From: June Grinstead [REDACTED]
Sent: 13 November 2018 09:33
To: Zac Denton
Subject: Re: 67 Norfolk Road
Attachments: 105.pdf

Block Plan

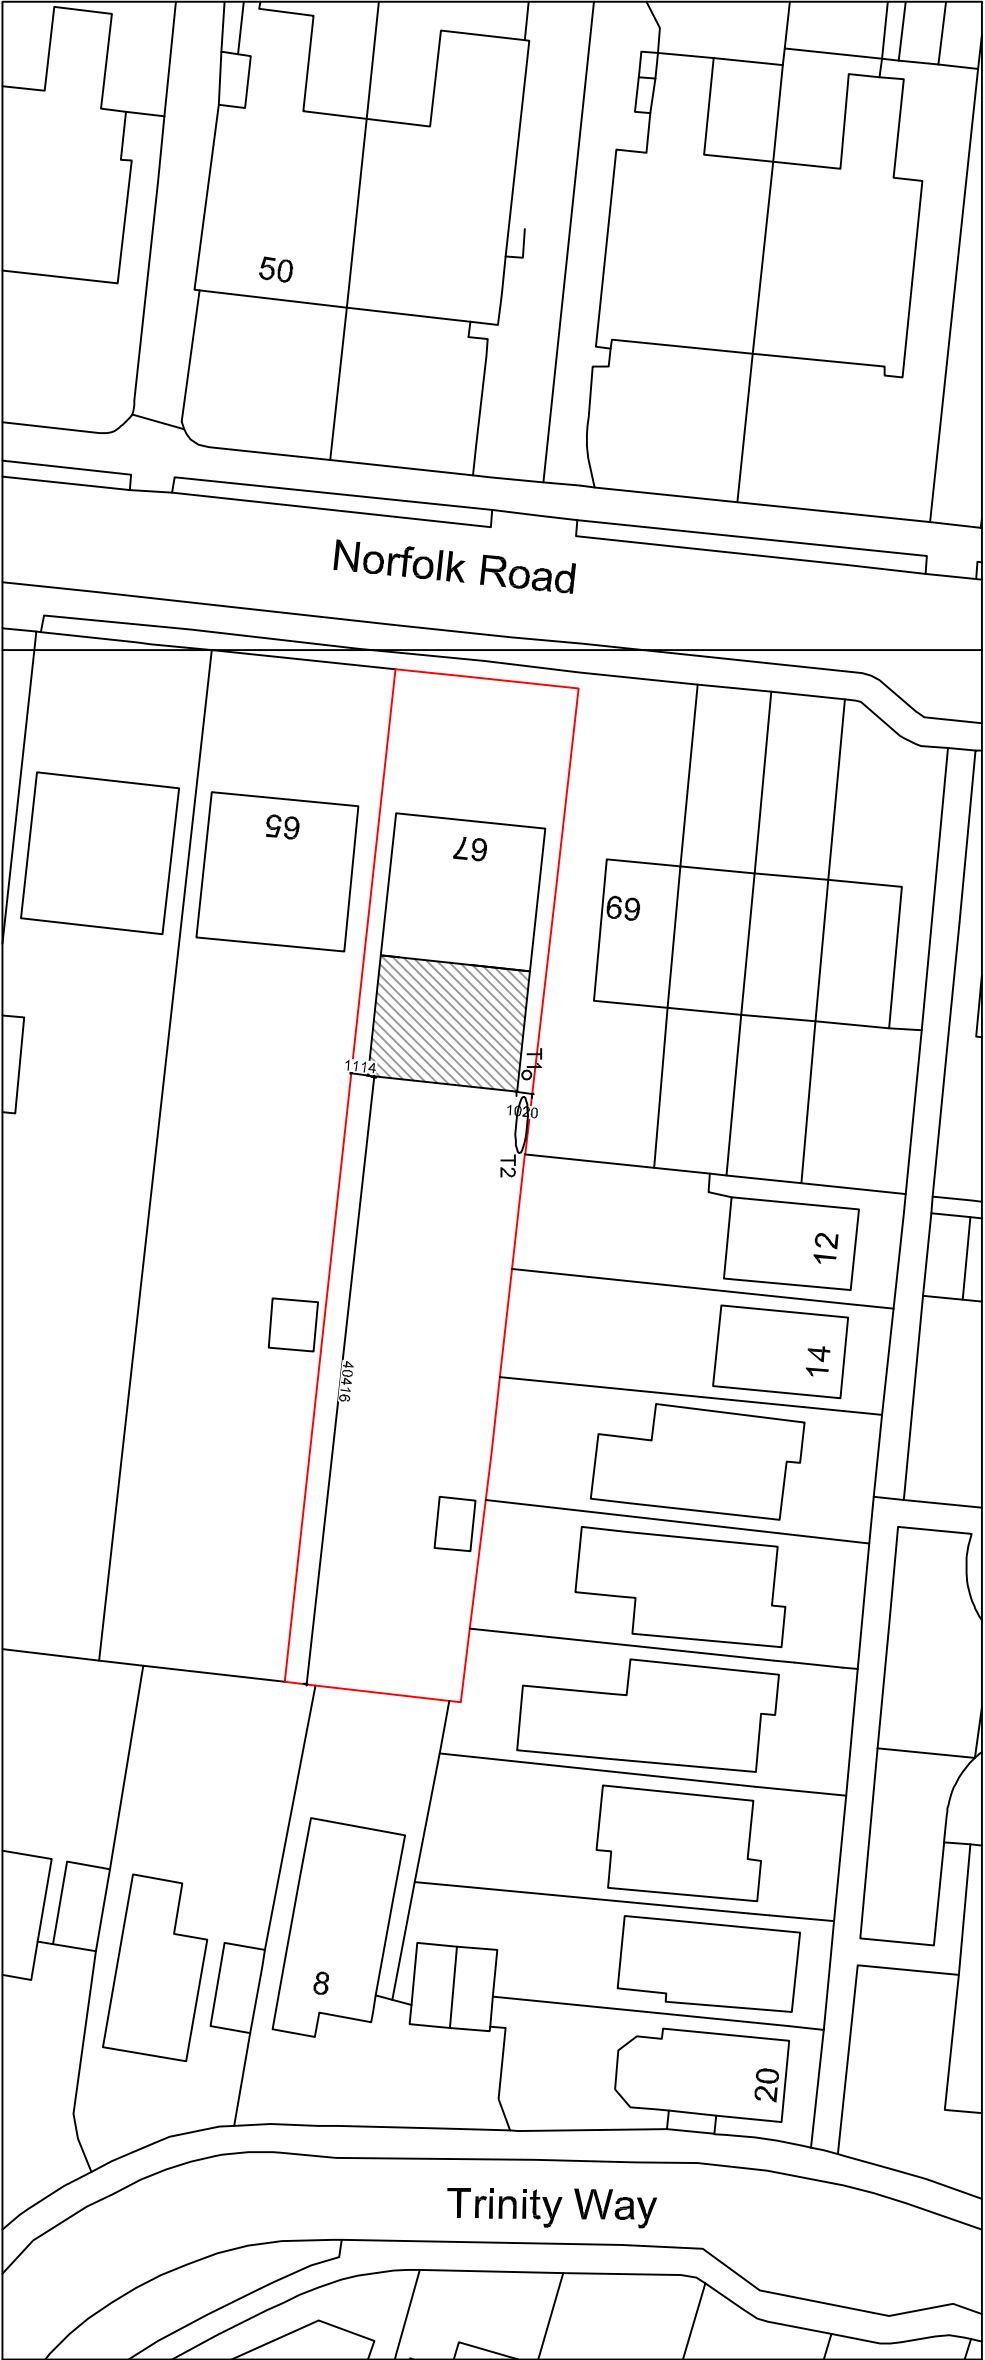
8m is a long extension under a householder planning application, if you feel this will be a problem please continue with the Notification of Larger Extension application. I'll contact you after the consultation period is finished to confirm if you have any final issues and push for the decision.

I very much appreciated your call this morning. Please find attached the revised Block Plan as requested. If there is anything else I can do please let me know.

Mrs F Broad 67 Norfolk Road Littlehampton West Sussex BN17 5HE	Landscape Plan		
	Project number	67NOR-18REVA	A105
	Date	13th November 2018	
	Drawn by	JG	
	Checked by	Checker	Scale

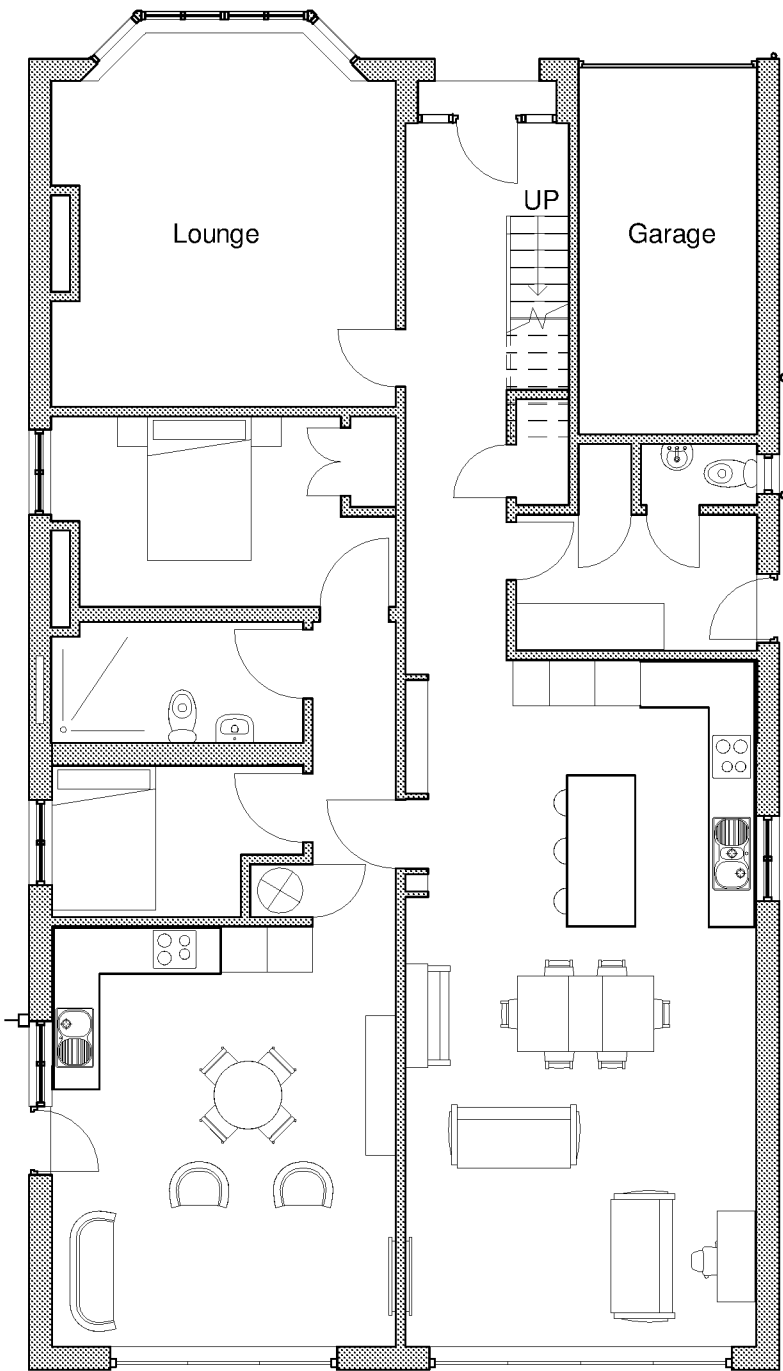
Information relating to planting/removal of foliage could be submitted on a landscaping plan. This could then be submitted to support the proposal.

The applicant has confirmed that she is going to plant bamboo along the fence to replace the Holly Tree and Shed, which grows higher than the fence. Would you like me to add this to the block plan?

Please find attached another drawing sheet, this shows the fence along the boundary and the location of the new planting.
